Castle Acre Parish Council, Castle Acre, Norfolk, Drovers Solar Farm (NSIP) application, Swaffham, Norfolk

Application by The Drovers Solar Farm Ltd. Ref EN0110013

DRAWING TITLE:
Figure 2-3 Field Numbering

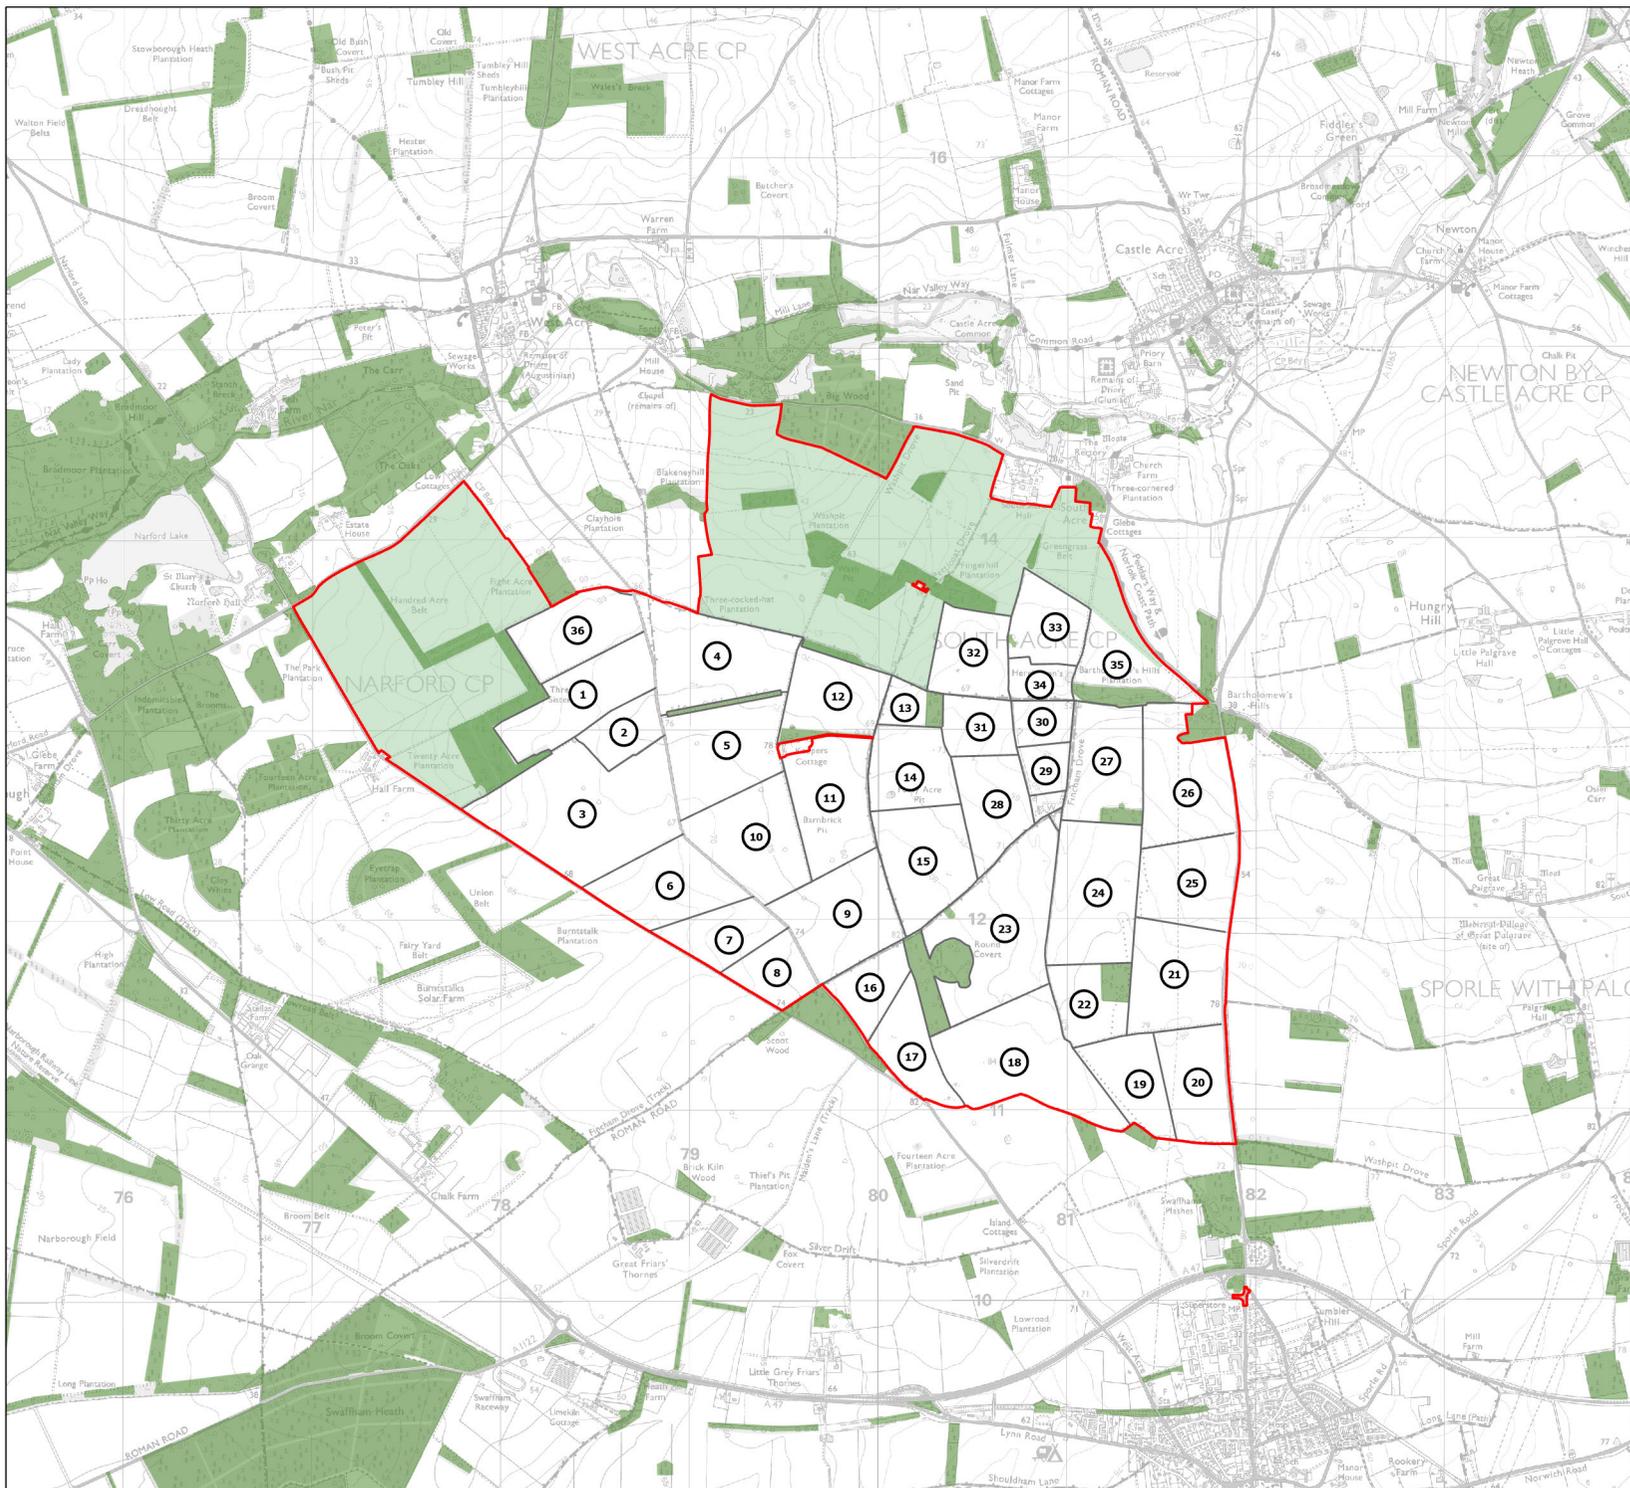
1 An important buffer would be created between the A1065 and the first enclosed industrial areas of panels to the west, (fields 19, 22 and 24) reducing the risk of Deer being forced through narrow corridors across the A1065, (**ref:** PEIR Masterplan Strategies, PEIR Fencing Strategy DWG No 9485 0272) endangering both Deer and motorists alike.

2 By removing development from these fields the impact on the Heritage village of Castle Acre could be reduced as one approaches from the South, travelling north on the A1065.

3 By removing development from these fields 20, 21, 25 and 26 the impact, on the overall historic landscape, visual and amenity, would also be potentially reduced.
